August 24, 2018

Re: MMC Staff Parking Garage | 222 St. John Street | Level III Site Plan  
Response to Public Comments 2

Thank you for coordinating the review of the Maine Medical Center Parking Garage project located at 222 St. John Street. This letter provides a summation of our responses to the comments received from various reviewers as part of the Level III Site Plan process. We have repeated the original comments in italics below, and our response follows each.

DATE OF APPROVAL
PLANNER: Neil Donaldson
PROJECT NO. 000207-2018

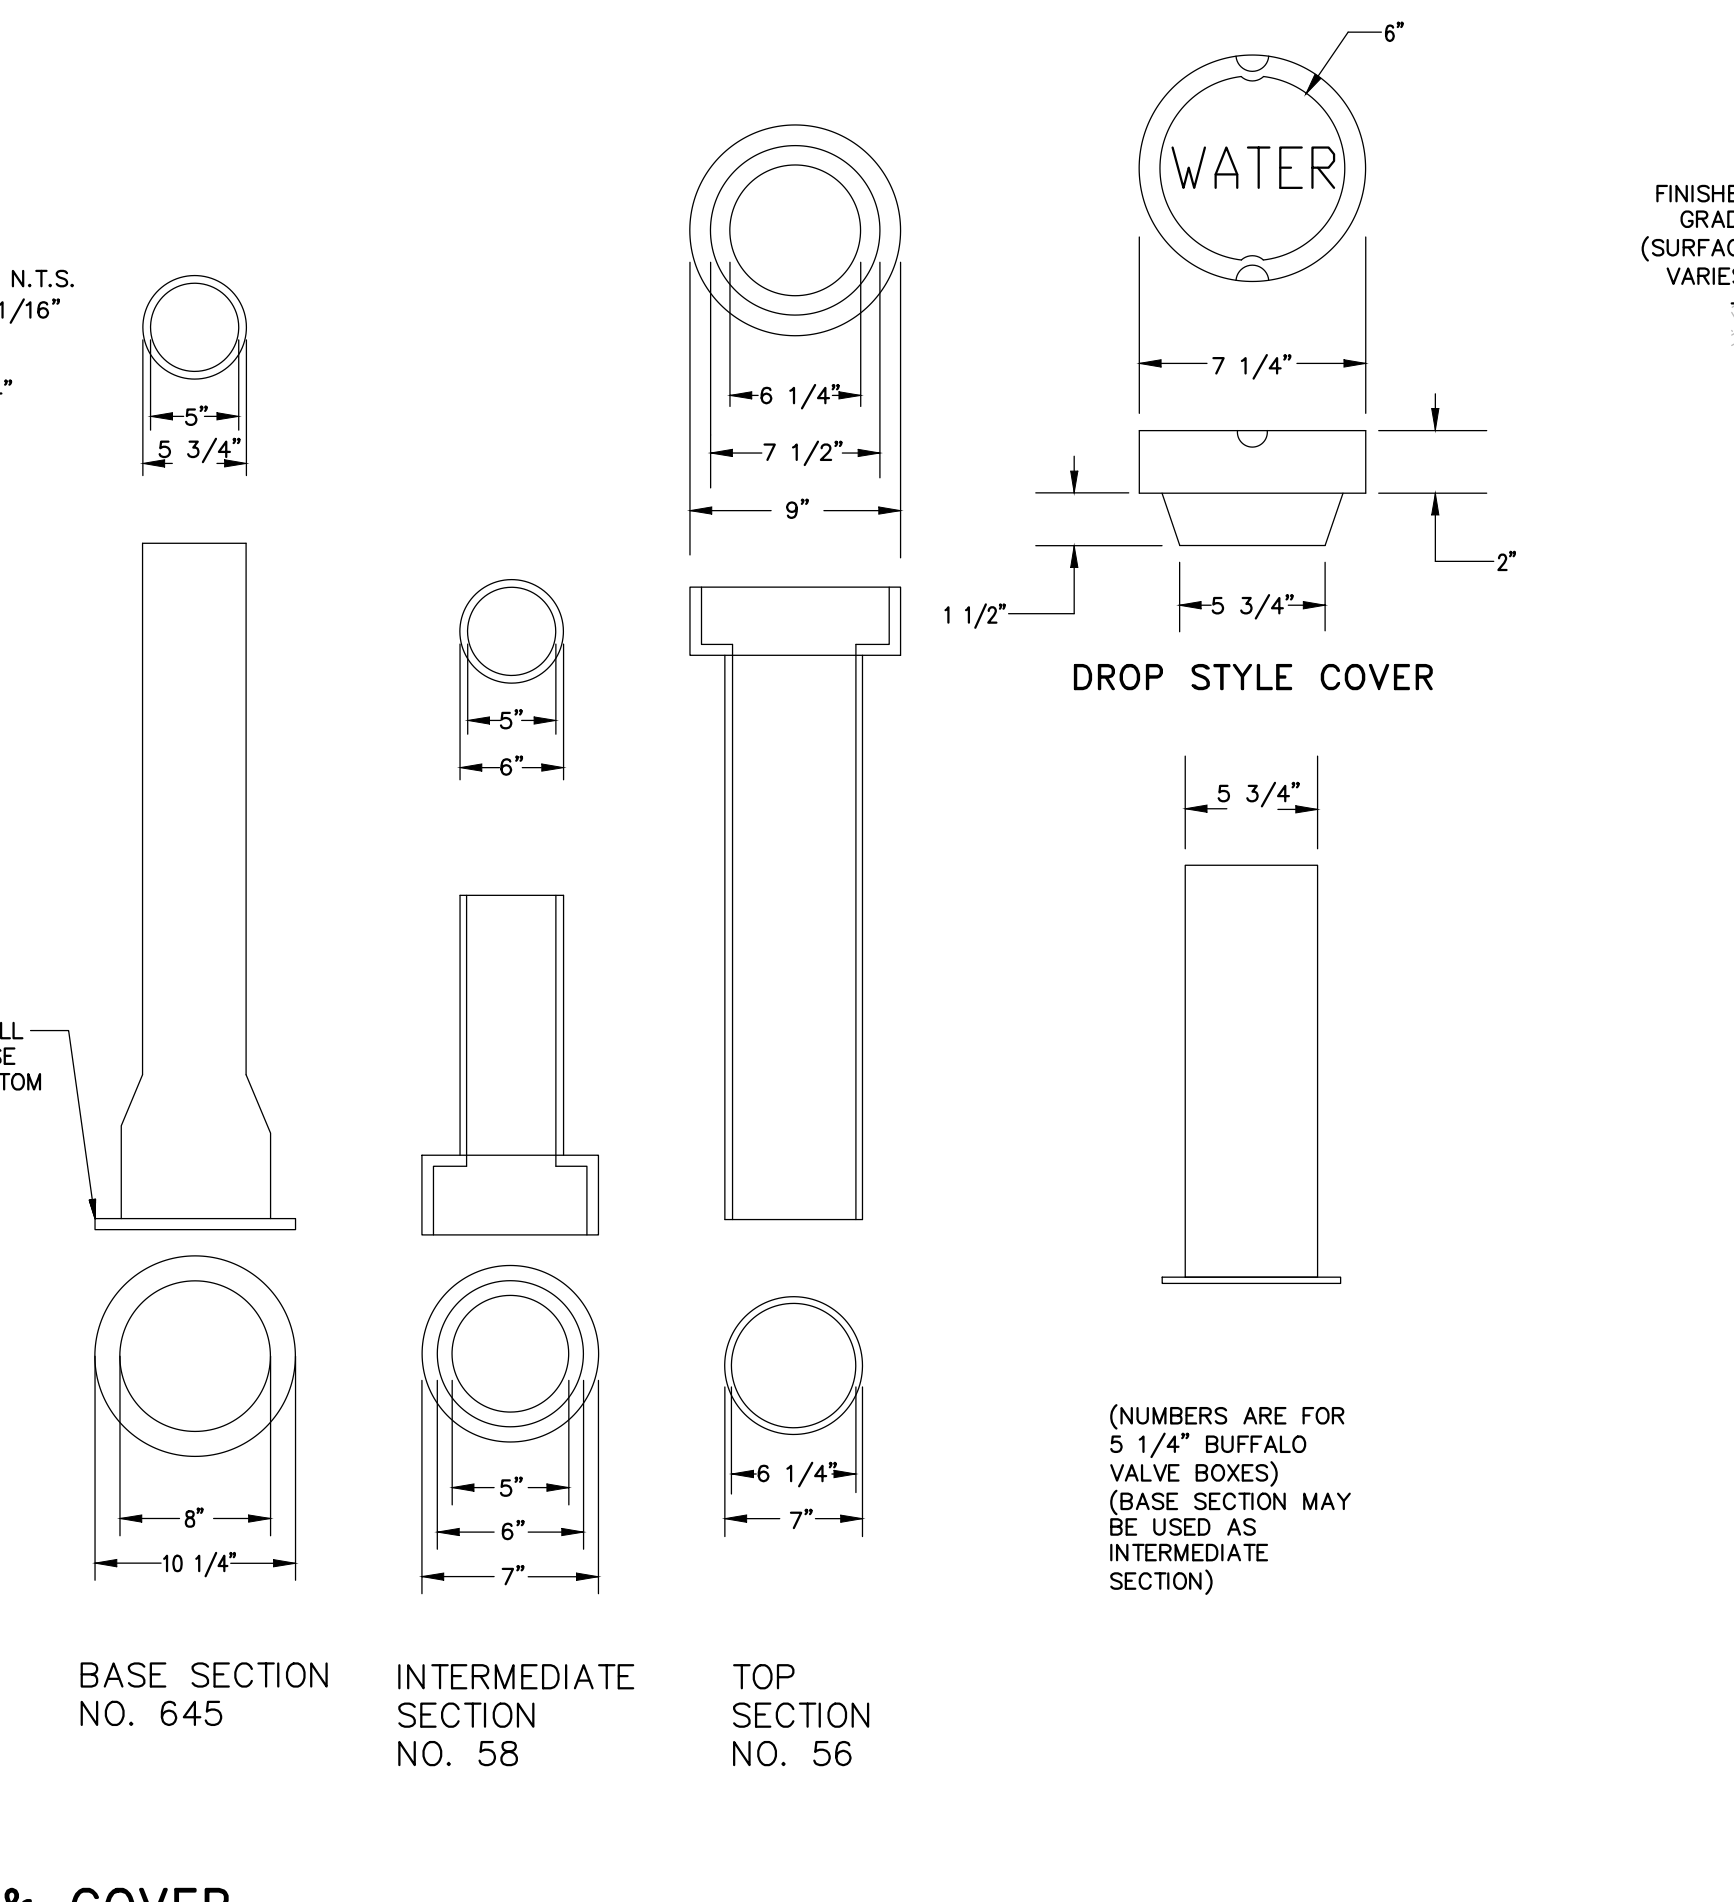
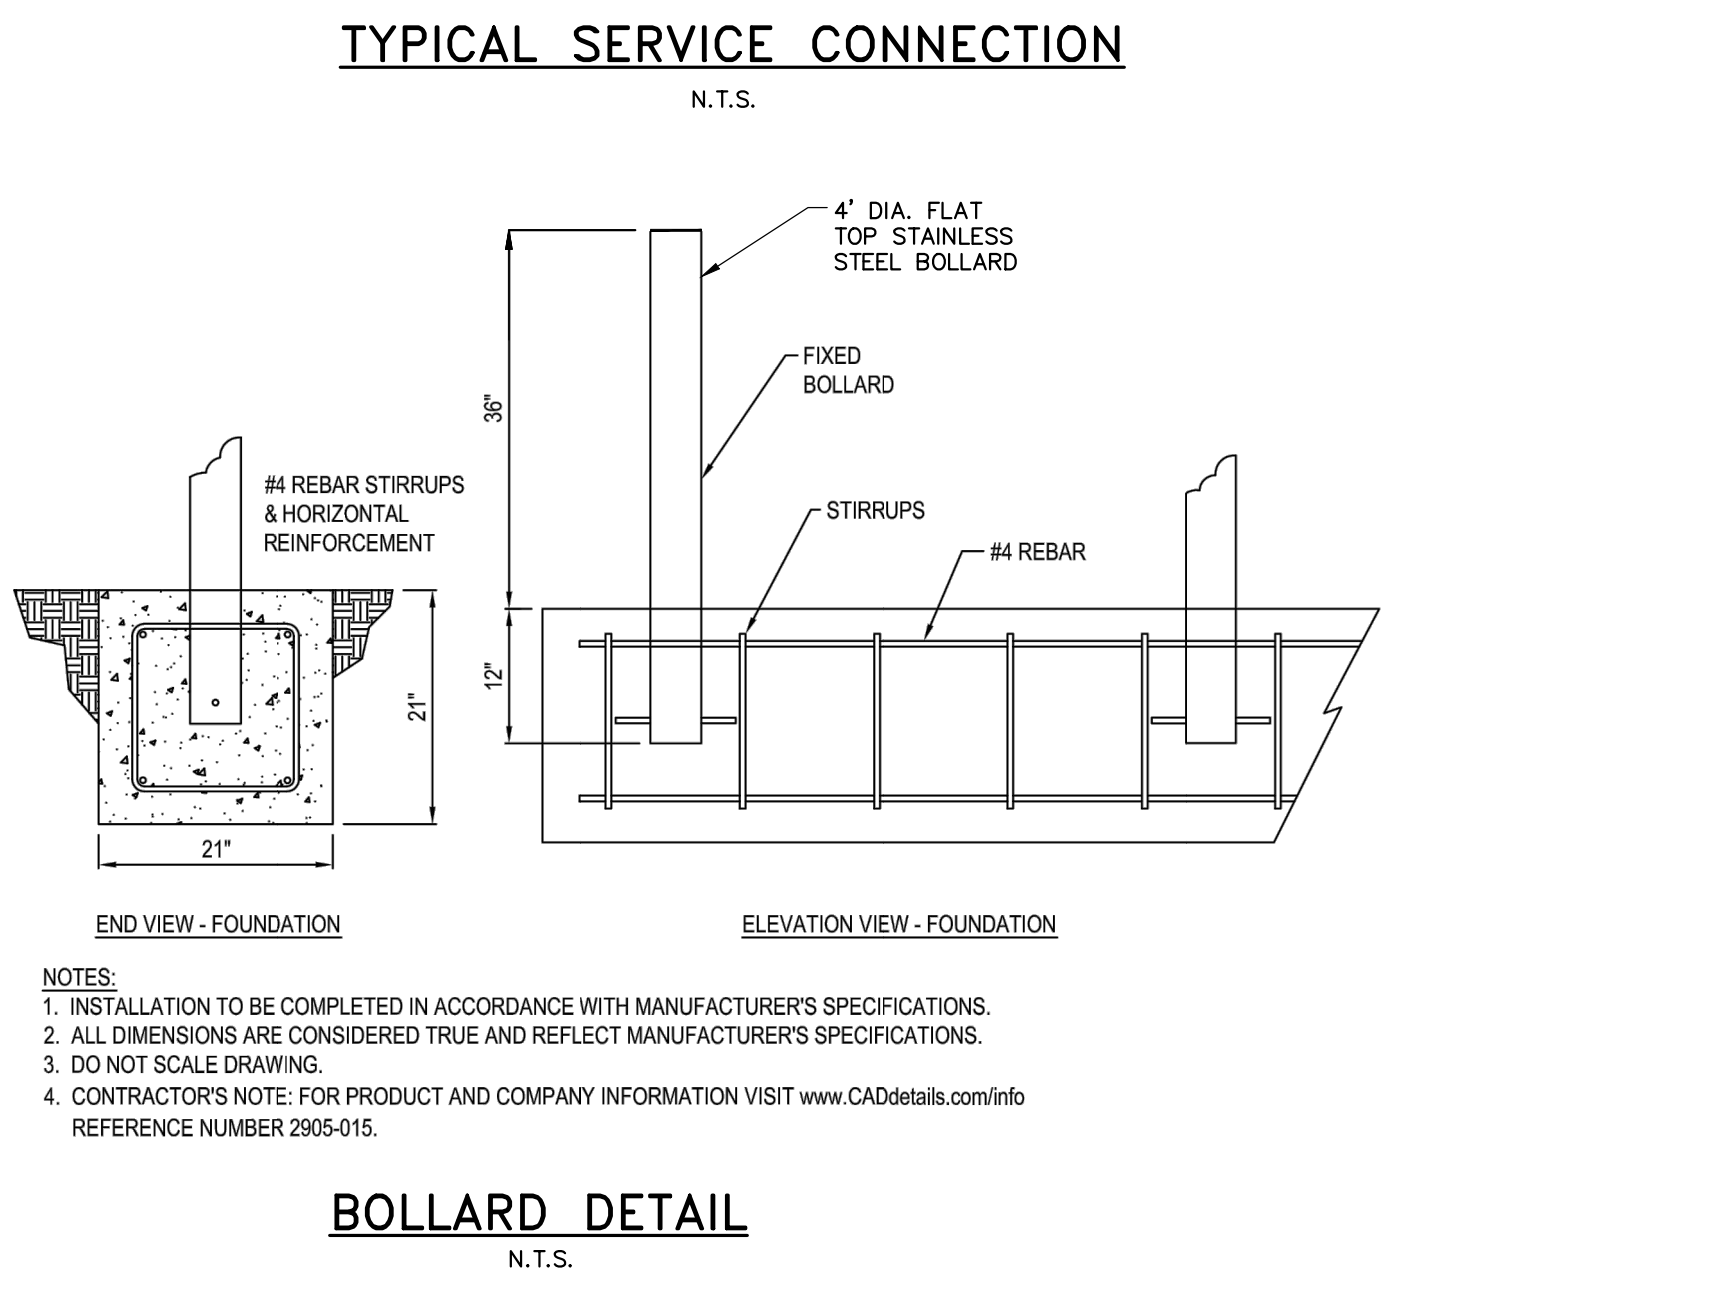
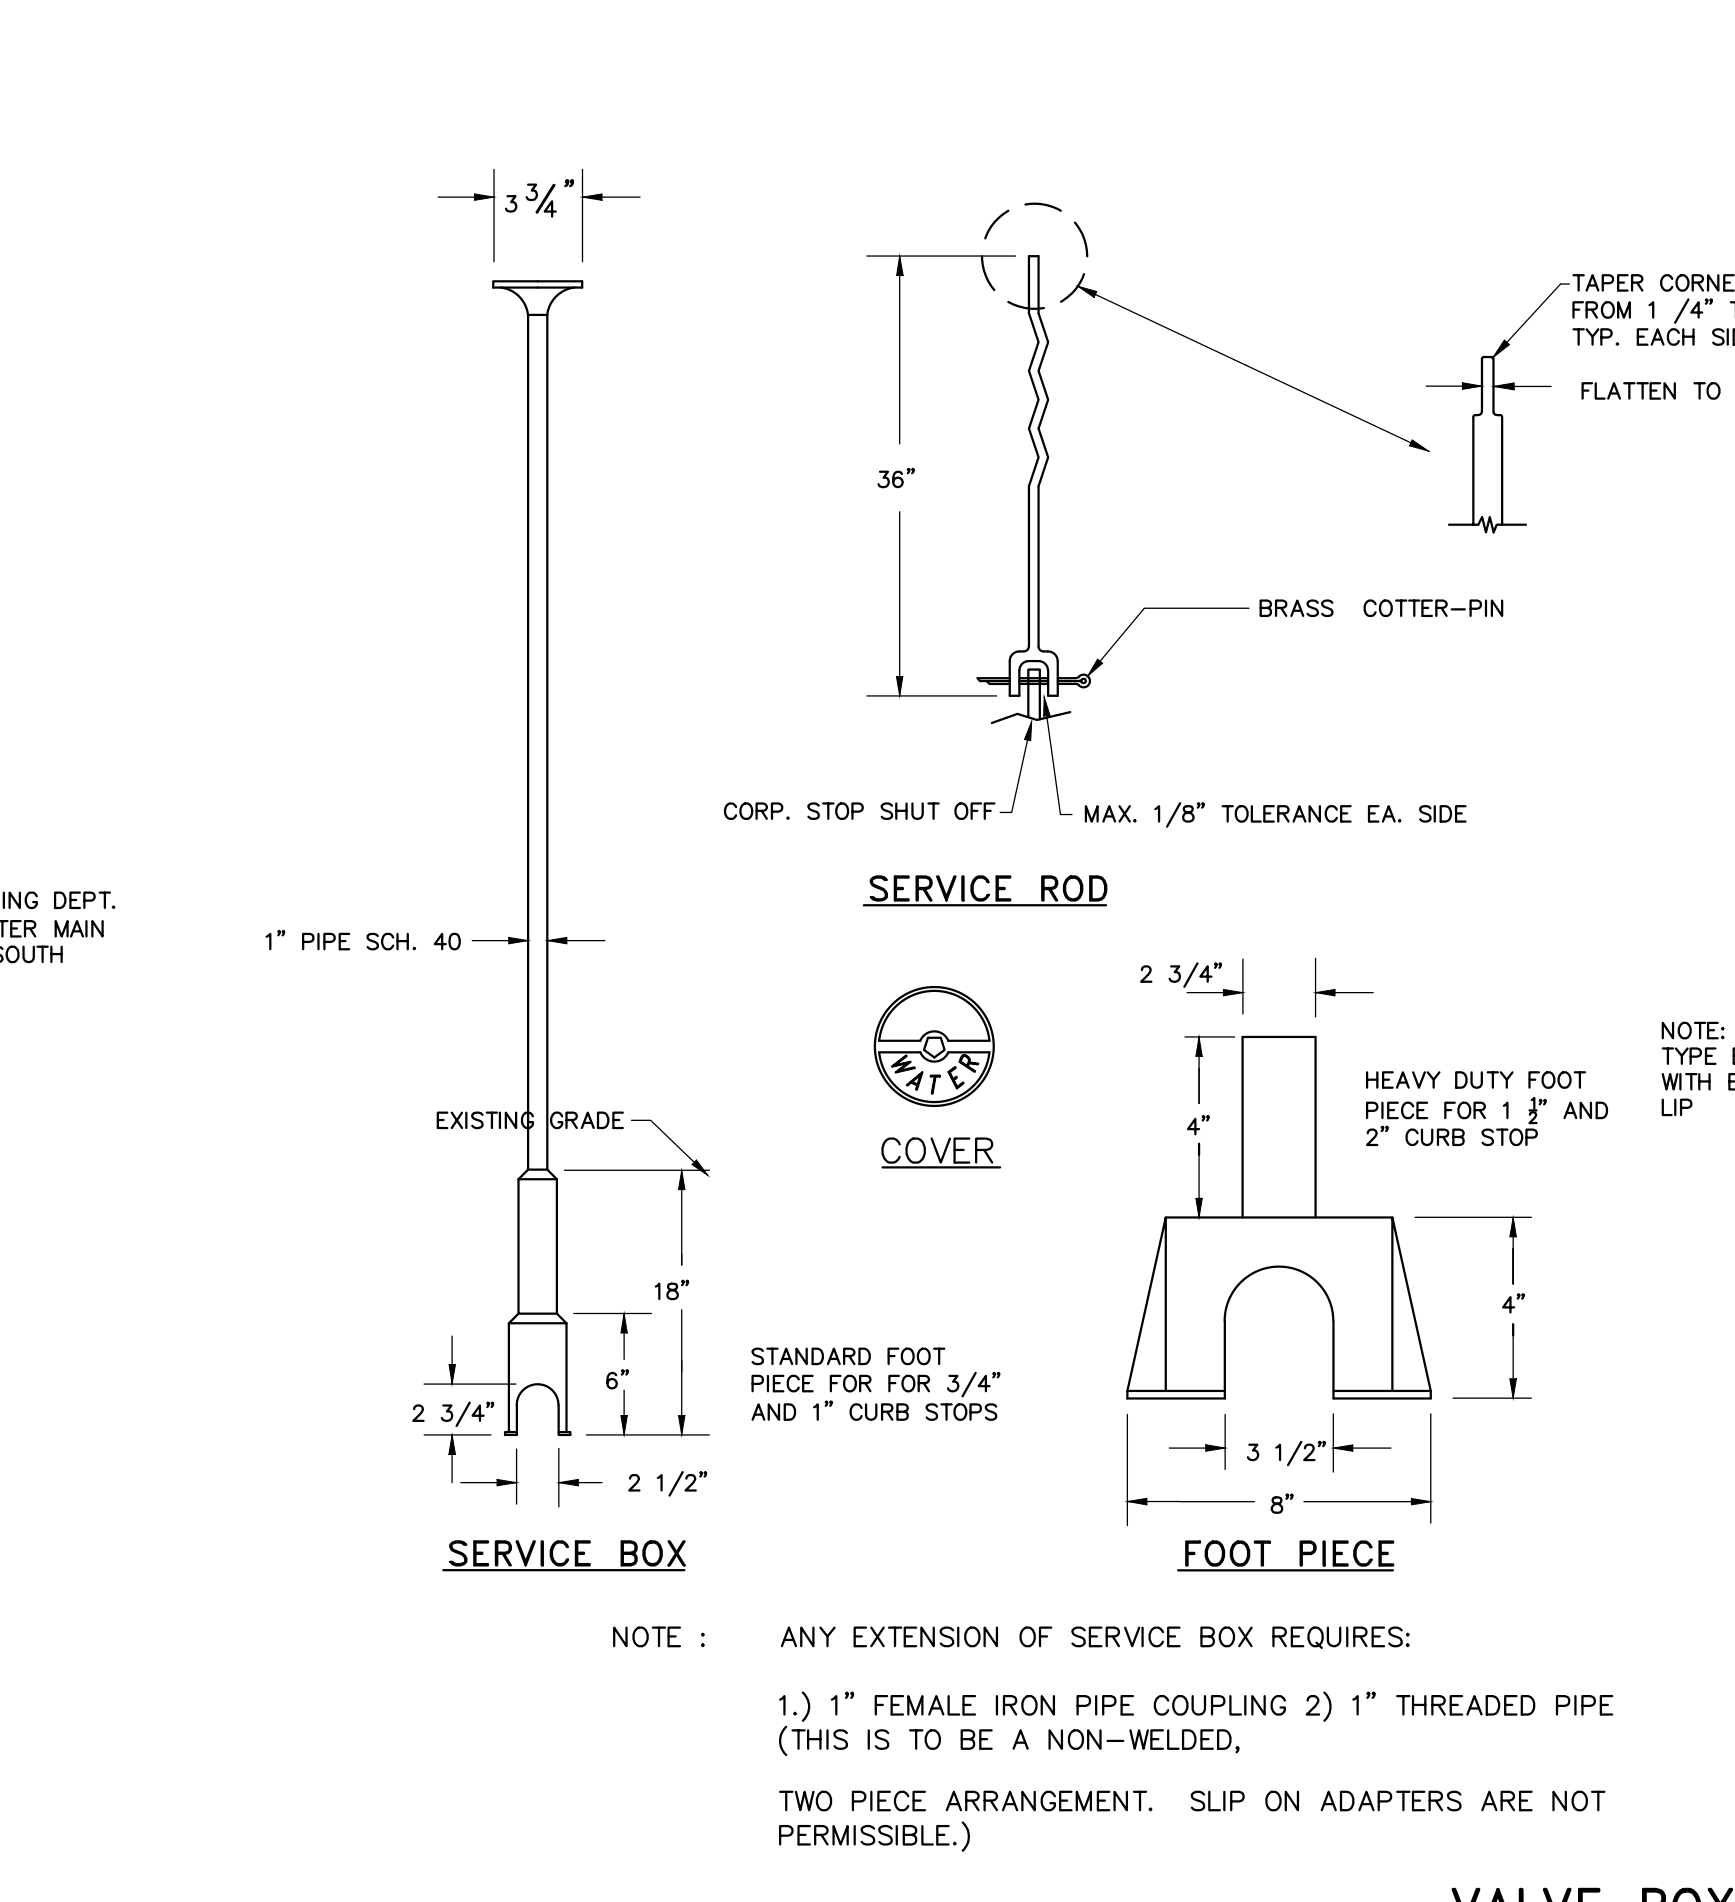
d. *Much of the proposed stormdrain has between 4 feet and 3 feet of cover. Detail on C-202 indicates rigid insulation shall be provided in these locations. No further action is necessary*

**Response:** Comment acknowledged.
